CITY OF ALBUQUERQUE

February 21, 2017

RE: **GAHP Silver Downtown**
800 Silver SW
Grading Plan Engineer's Stamp Date: 1/30/2017
Hydrology File: K13D013

Based upon the information provided in your submittal received 2/10/17, the Grading Plan is not approved for Building Permit. The following comments need to be addressed for approval of the above referenced project:

A5 ENLARGED GRADING PLAN
1" = 10'-0"

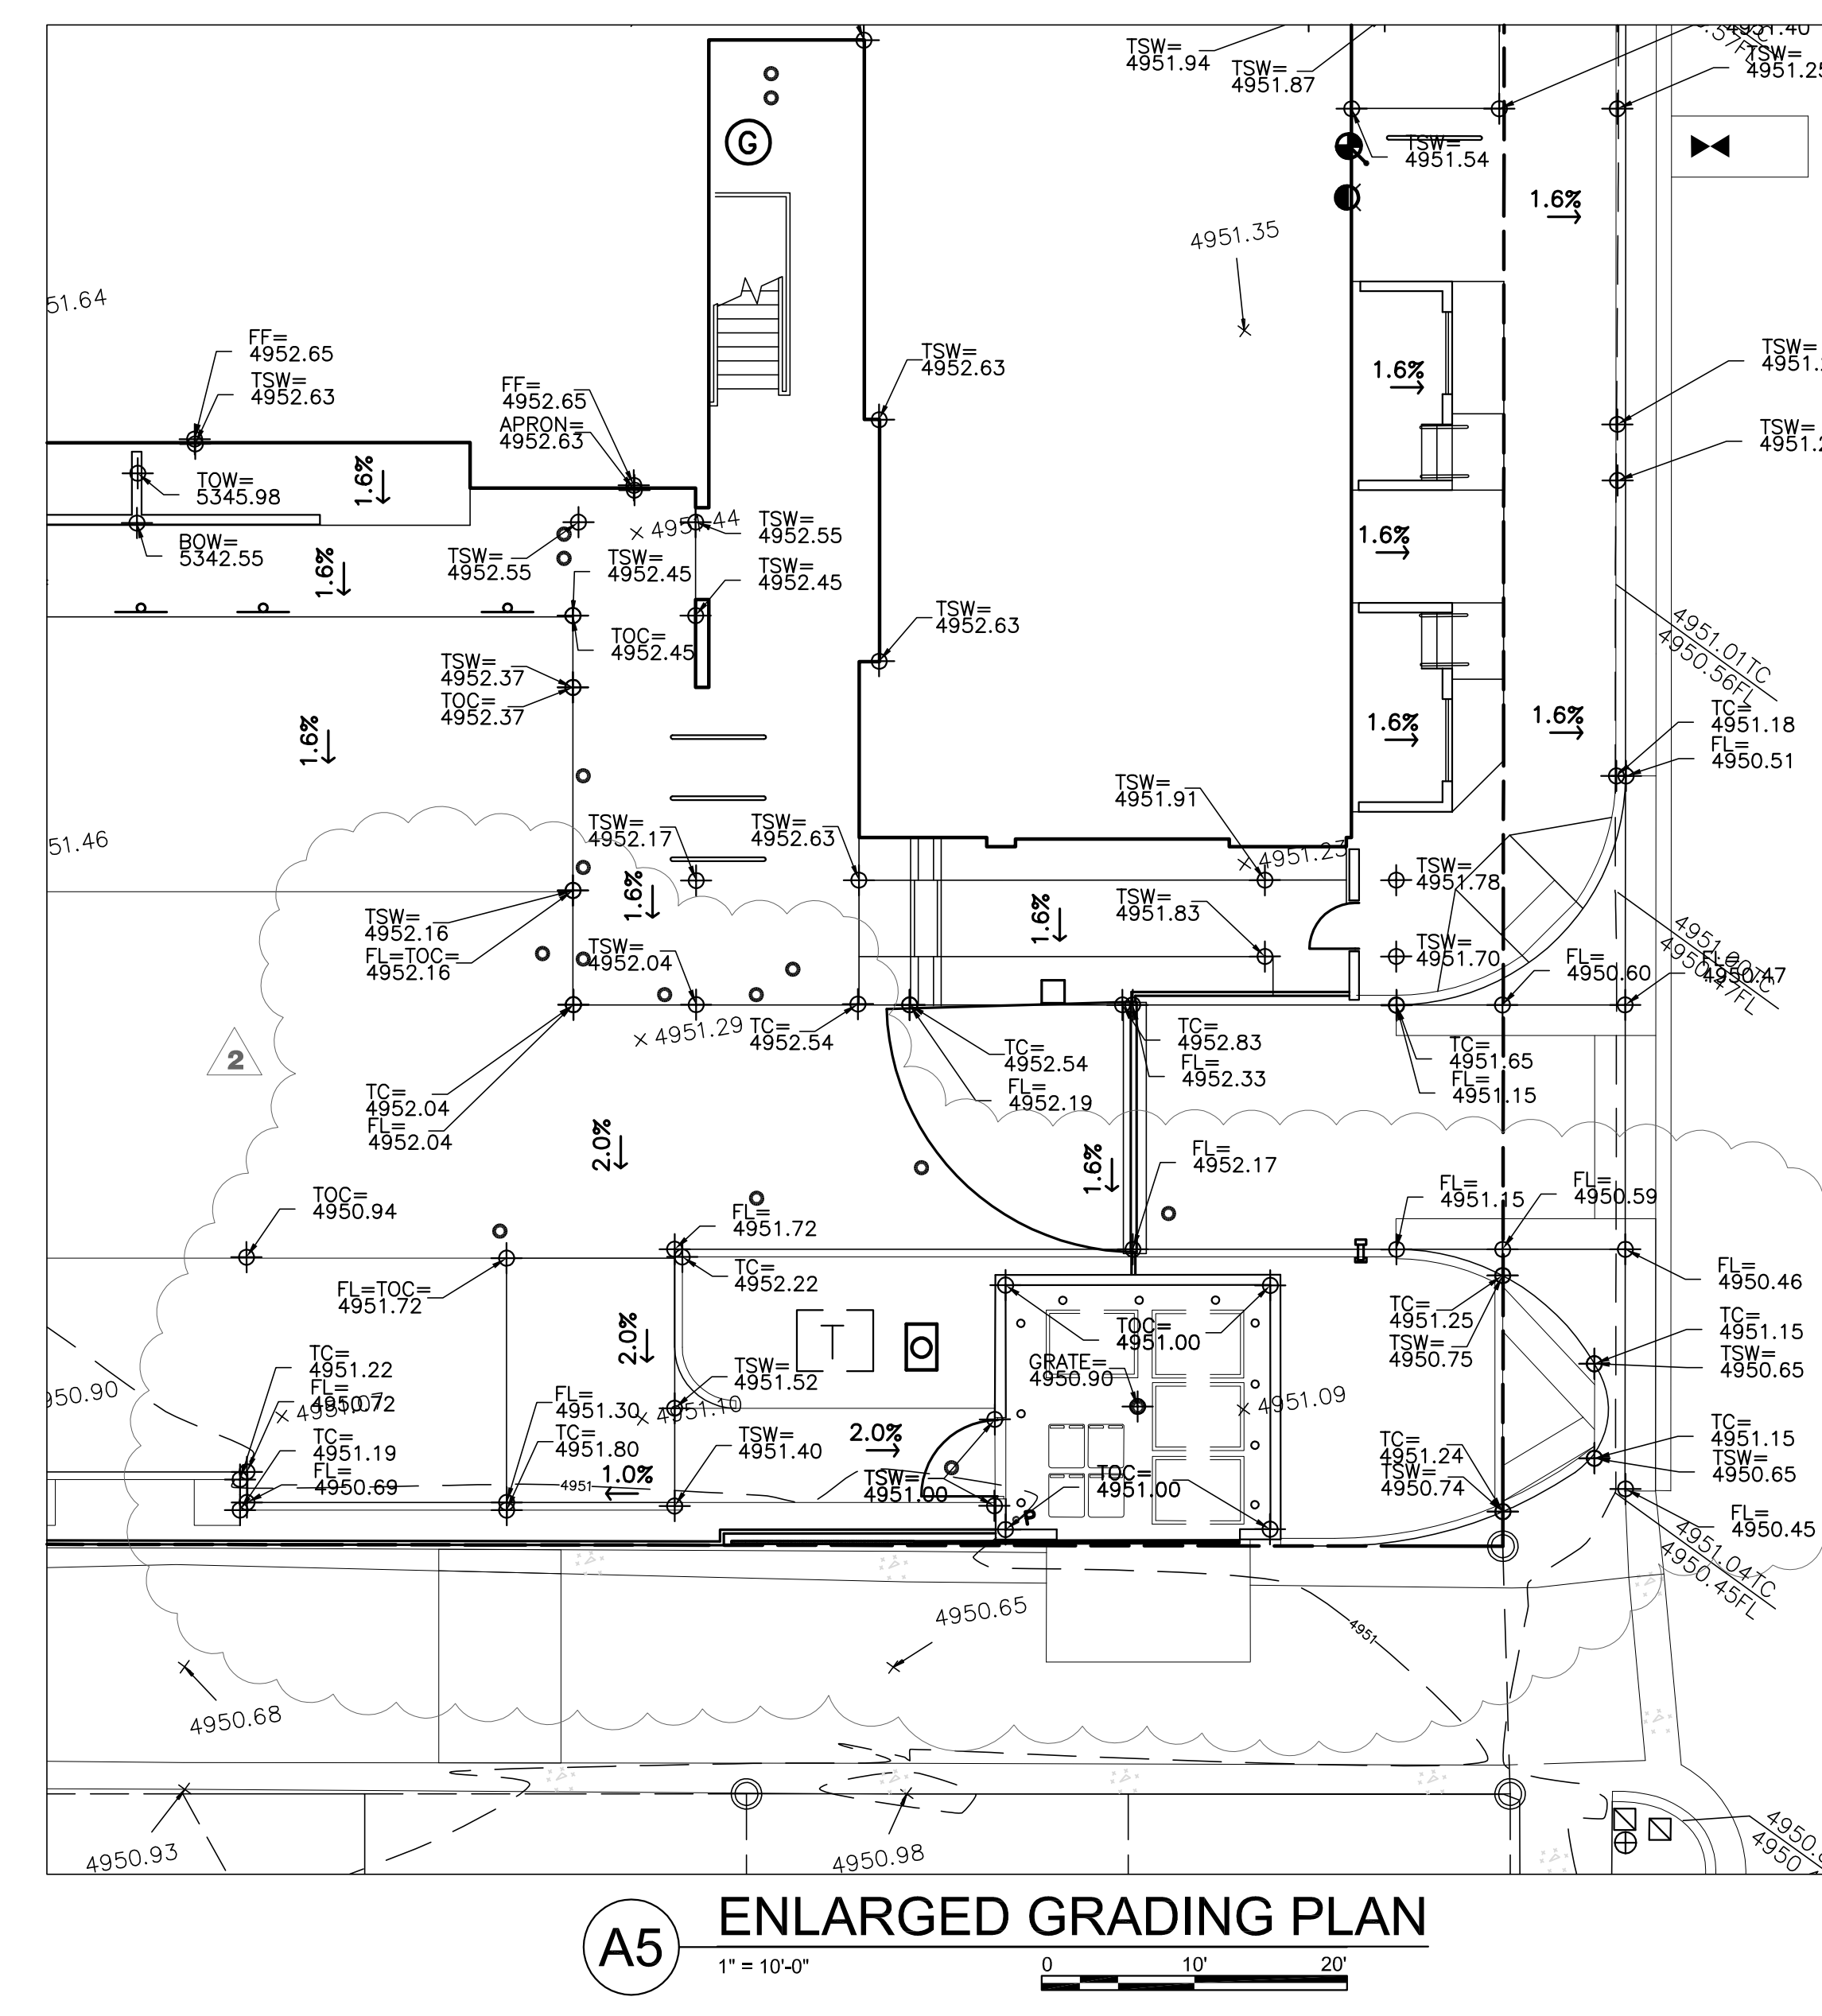
7. There is a grate elevation shown in area A5. Is there an interior storm drain network or is this to plumb the trash area into the sanitary sewer?
